BUILDING DESIGN SERVICES

8.7.14

Re: Proposed Extension The Old Barn Gravels Farm Schole Hill Penistone.

ROOF PLAN 1:100

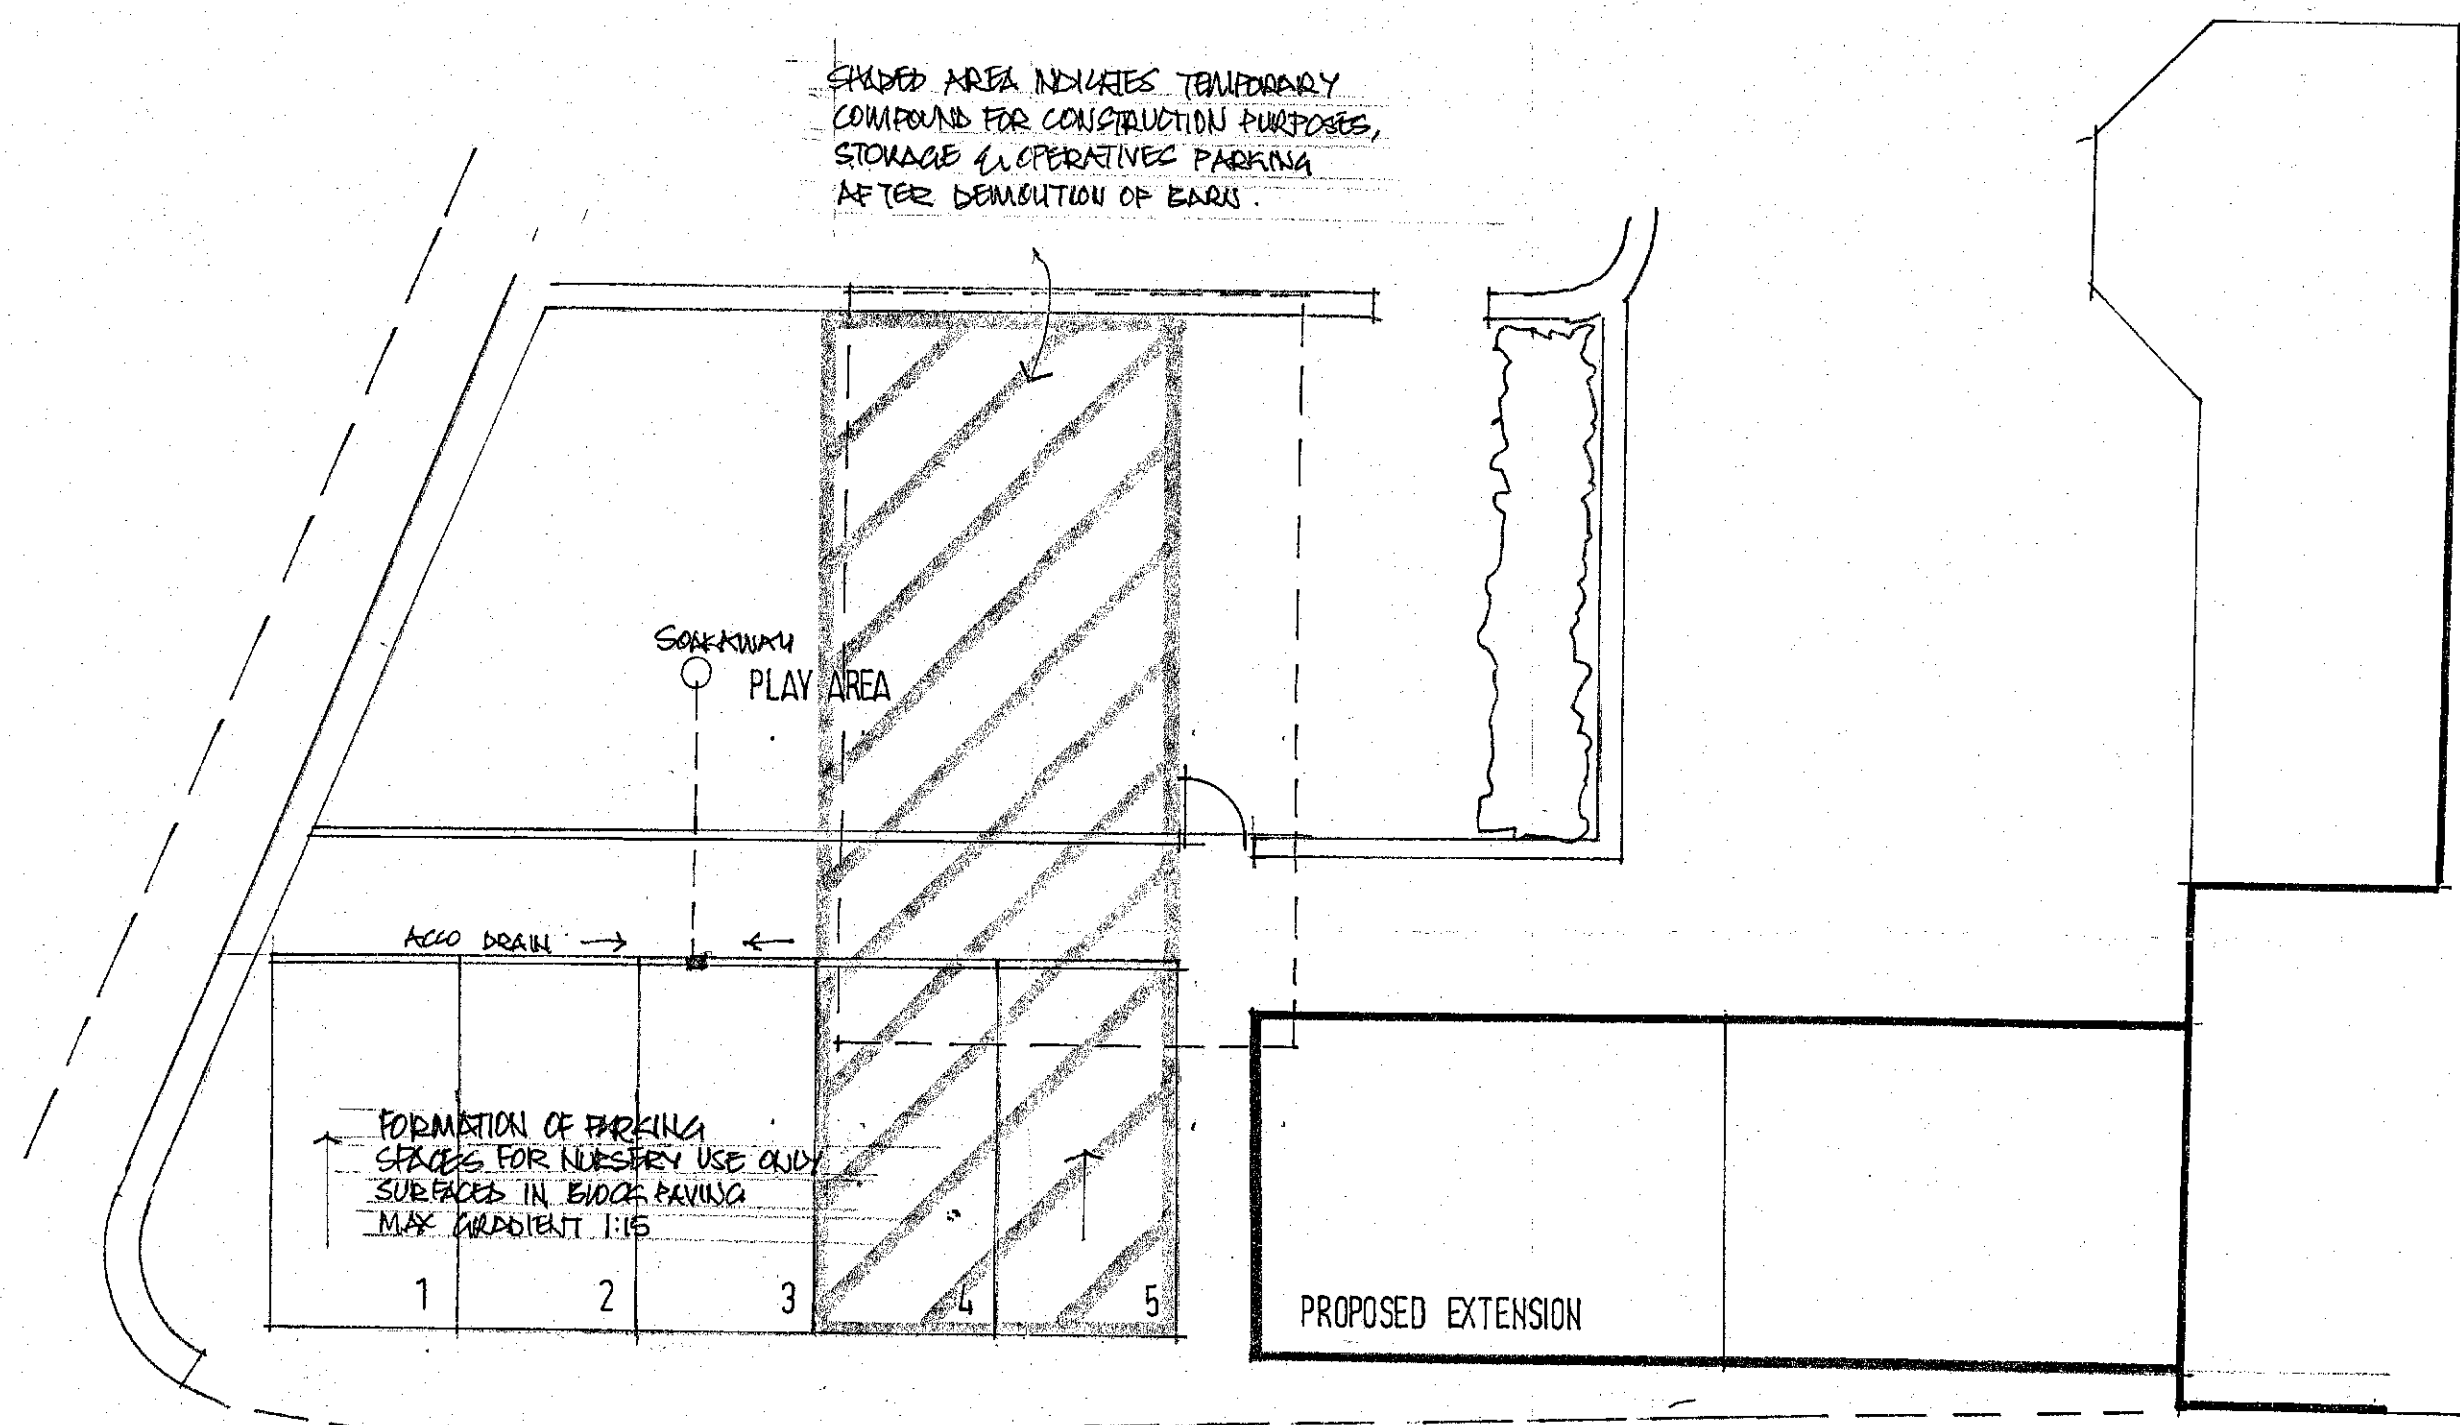
Following your recent email and copy of correspondence from your Highways department I am enclosing amended plans clarifying the parking allocation. I have also indicated an area to be used as a storage and parking area during construction of the extension. Parking for the occupants of the Old Barn has always been separate from the nursery parking and i have indicated this on the enclosed plan.
